Application for a Non-Material Amendment Following a Grant of Planning Permission

Construction of a single storey rear extension with part first floor extension (including loft conversion with gable end) and conversion of the garage to a habitable room and associated external works (re-consultation - amended description of development).

23/3653/HD

DATE : 2023.10.12
 DRAWING No: P1.3
 DRAWING TITLE : PROPOSED LOFT PLAN
 SCALE : 1:100@A3

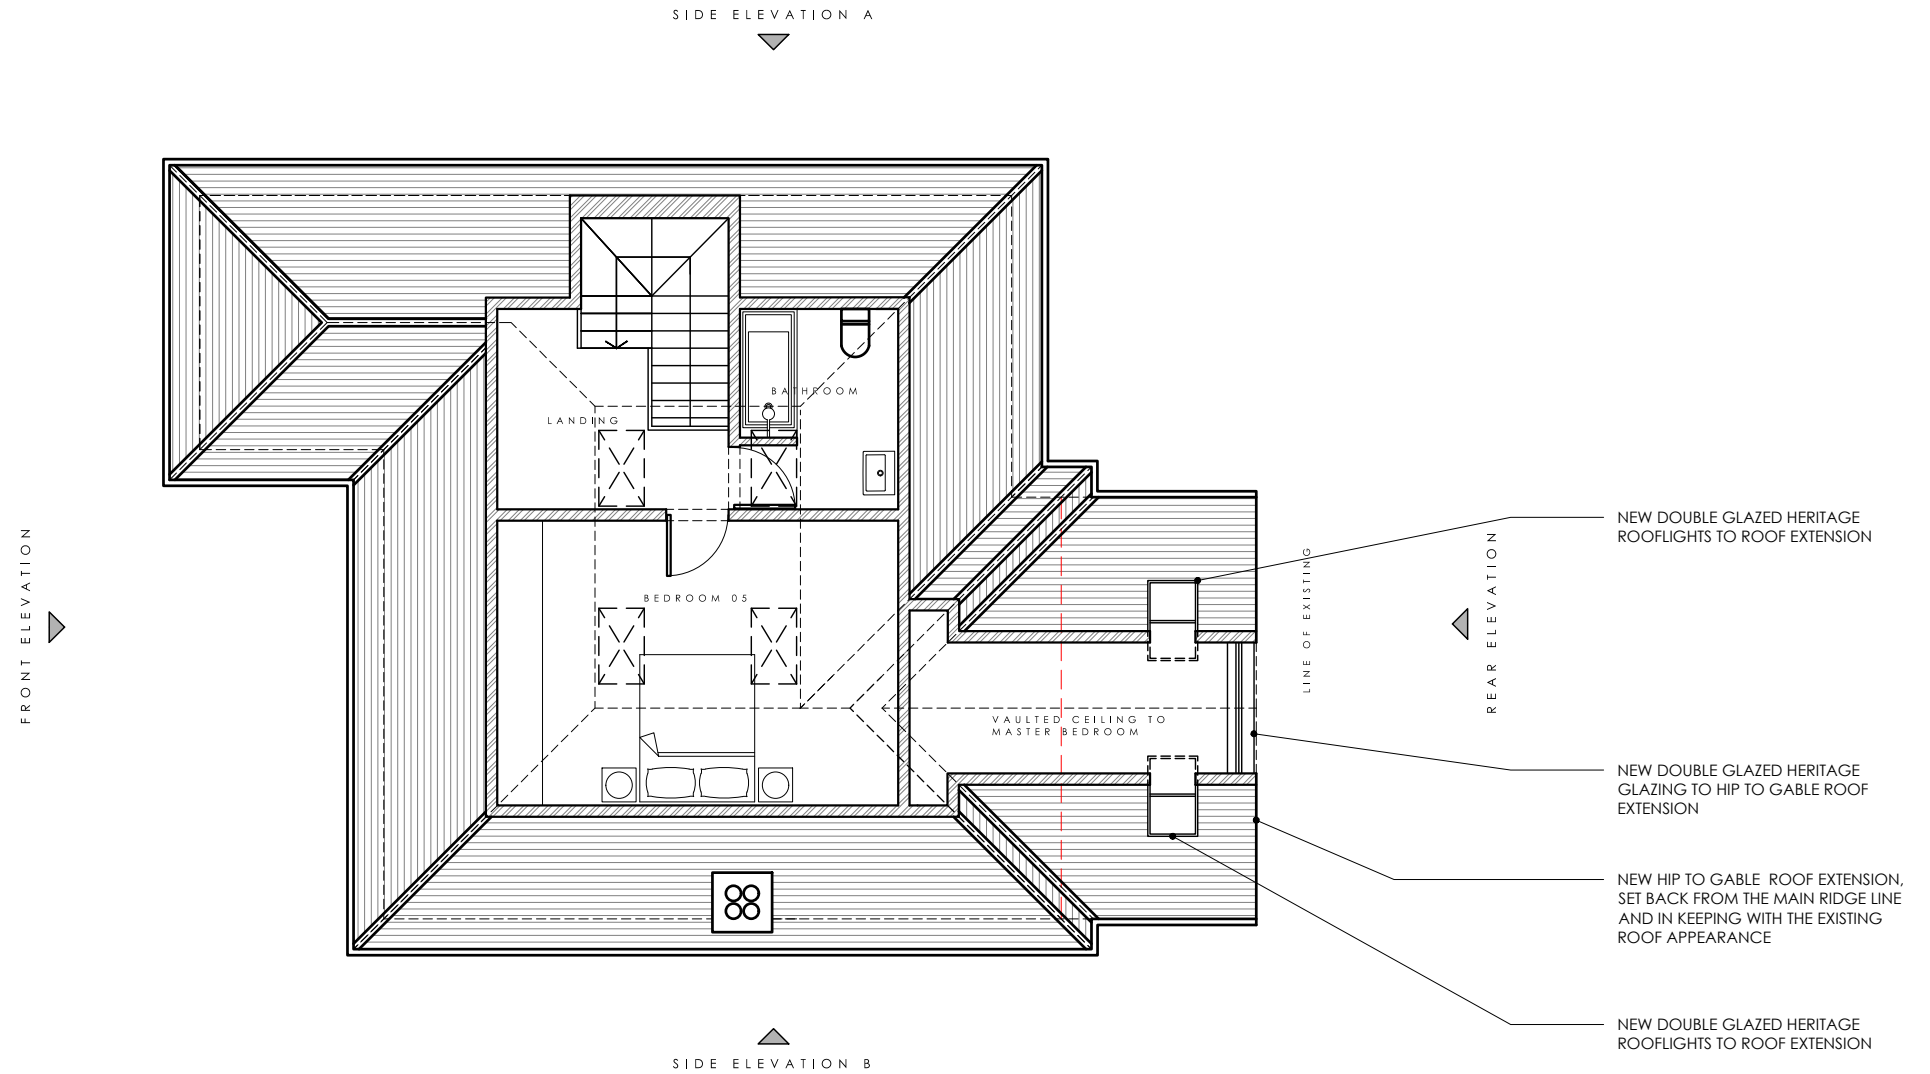
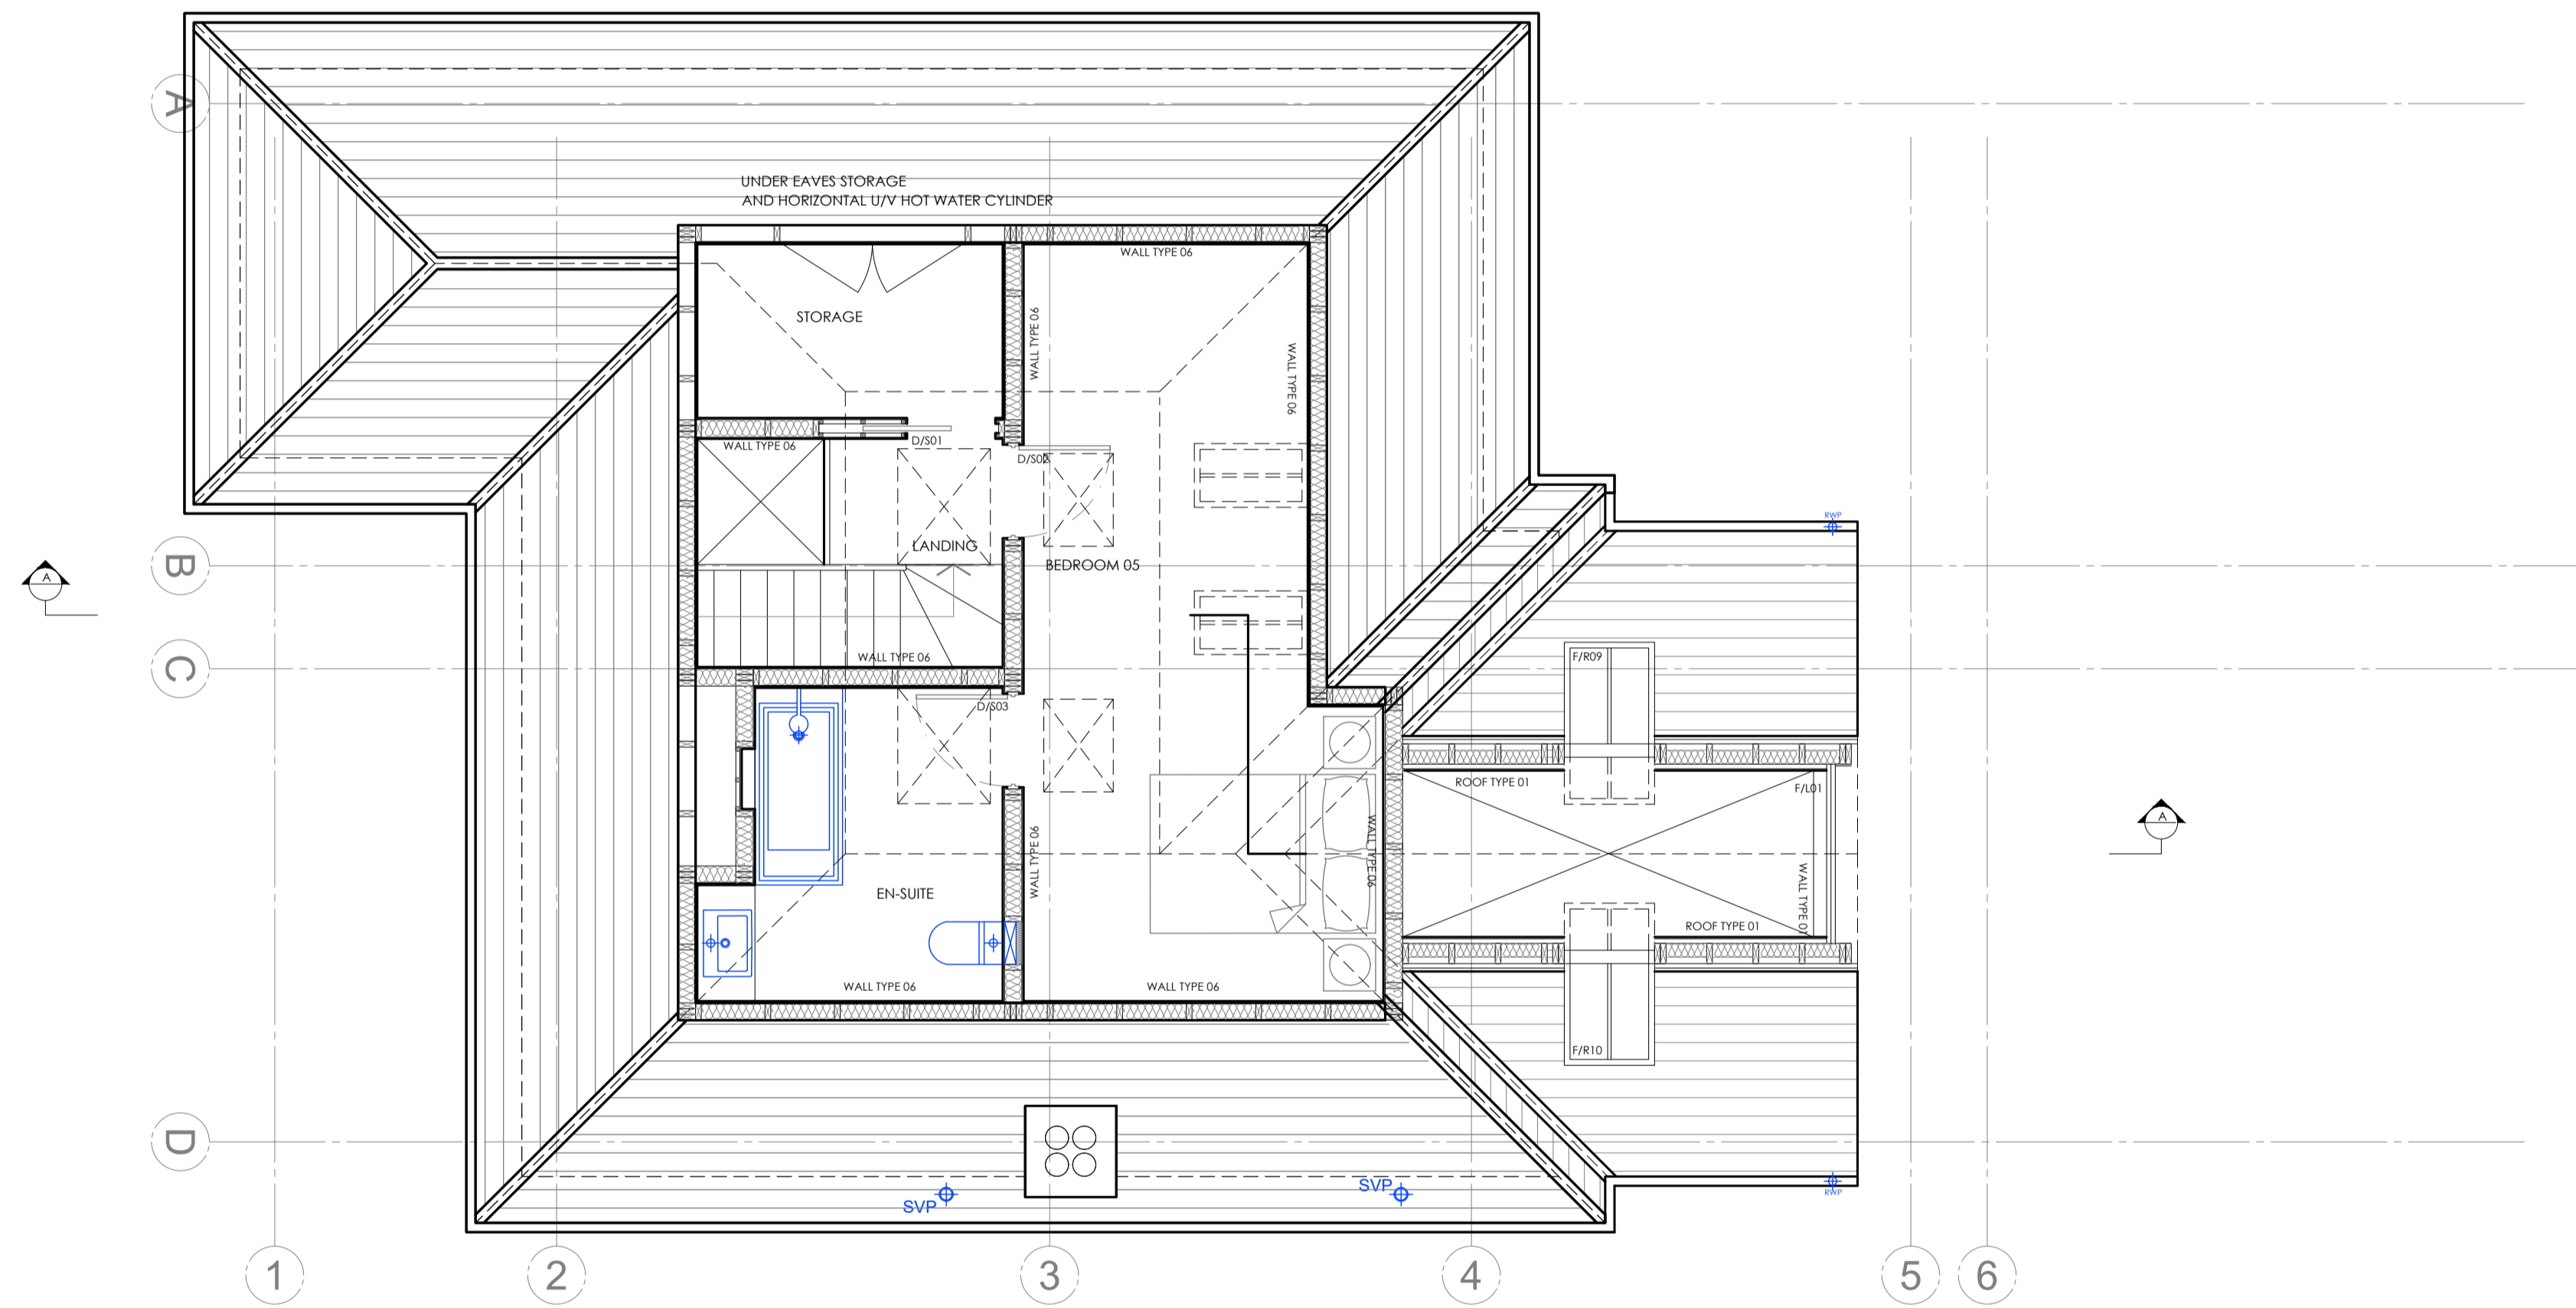
2 no additional conservation roof lights in existing rear roof slope

To achieve natural lighting within the converted loft area.

P1.3 Proposed Loft Plan
P1.4 Proposed Roof Plan
P1.8 Proposed Rear Elevation

C33 Proposed Loft Plan
C34 Proposed Roof Plan
C36 Proposed Rear Elevation
